Recommendation Report for Planning Permission for Works or Extension to a Dwelling

REF NO: FP/167/25/HH

LOCATION: 7 Lindsey Court
Felpham
PO22 8JQ

PROPOSAL: Erection of self contained annexe in rear.

Proposed East Elevation

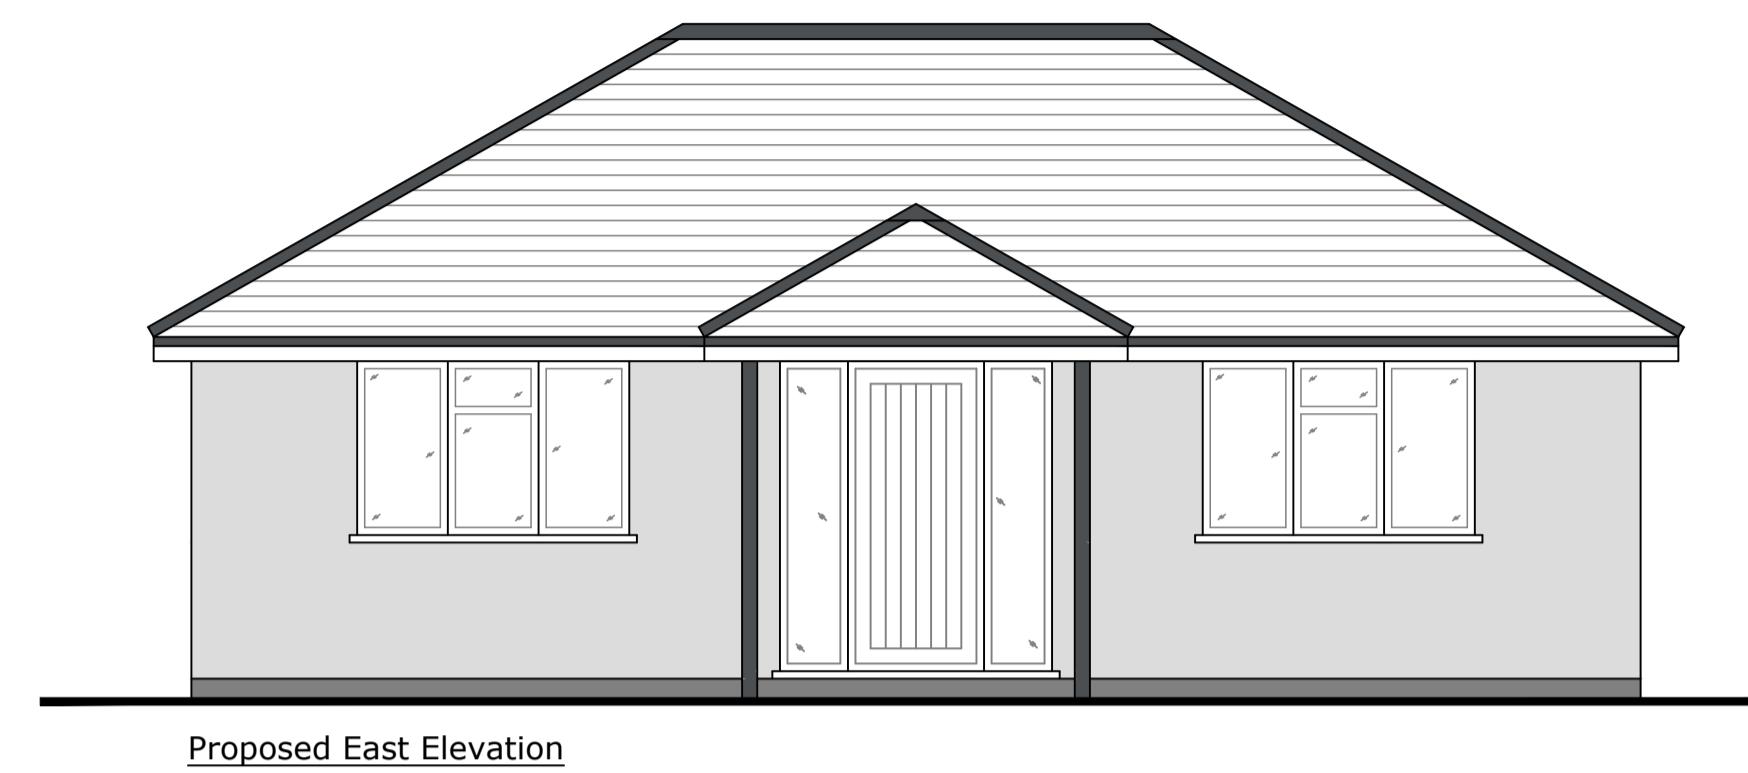
Two windows and a door, flanked by full-length glazing, are proposed on the east elevation. Bifolding doors are proposed on the north elevation, opening on to the rear garden. As the annexe would be single storey, the proposed fenestration would be at ground floor level, facing either towards the centre of site or north on to the garden boundary. These views would not result in harm to neighbouring amenity by way of overlooking and could be achieved from the existing rear garden.

Proposed Ground Floor Plan

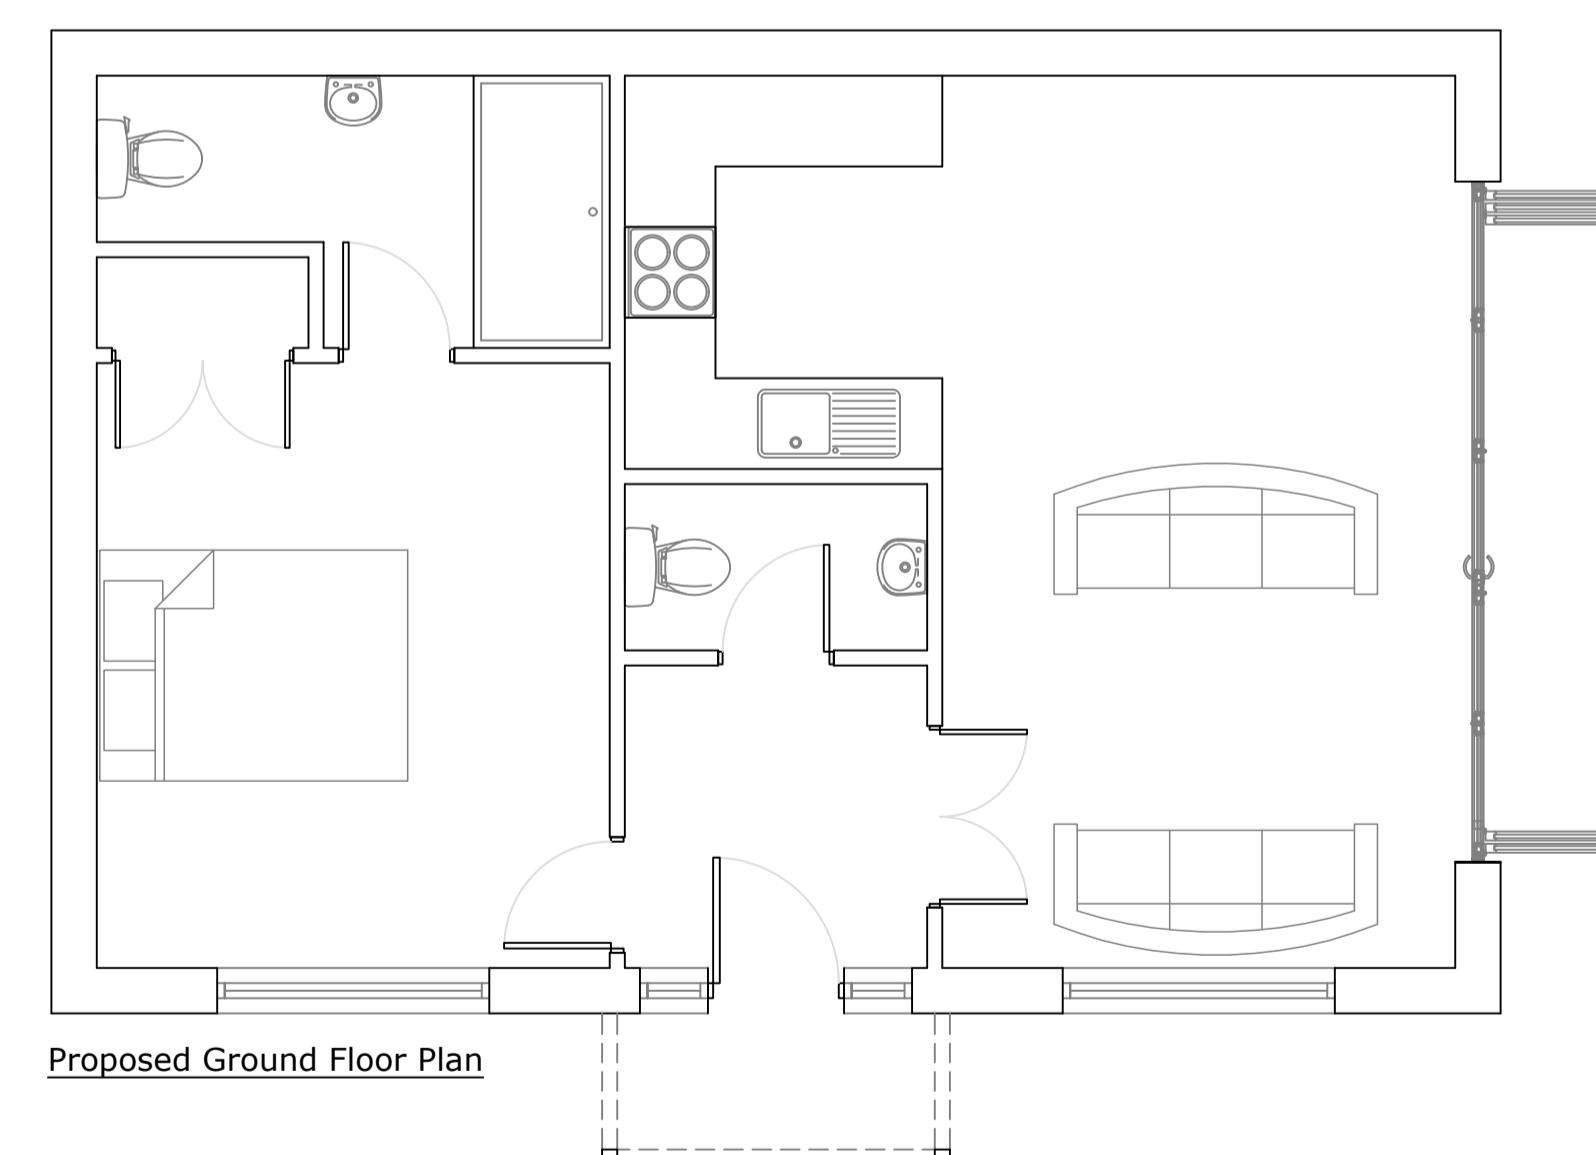
The annexe would have a footprint of 9.6m x 6.5m and a hipped roof form with a ridge height of 4.5m. A lightweight, open porch is proposed on the front elevation, which would protrude approximately 1m. The annexe would include one bedroom, one bathroom, a kitchen and living accommodation. The annexe would have an ancillary use to the host dwelling (which would be secured by condition), replacing three outbuildings currently in situ.
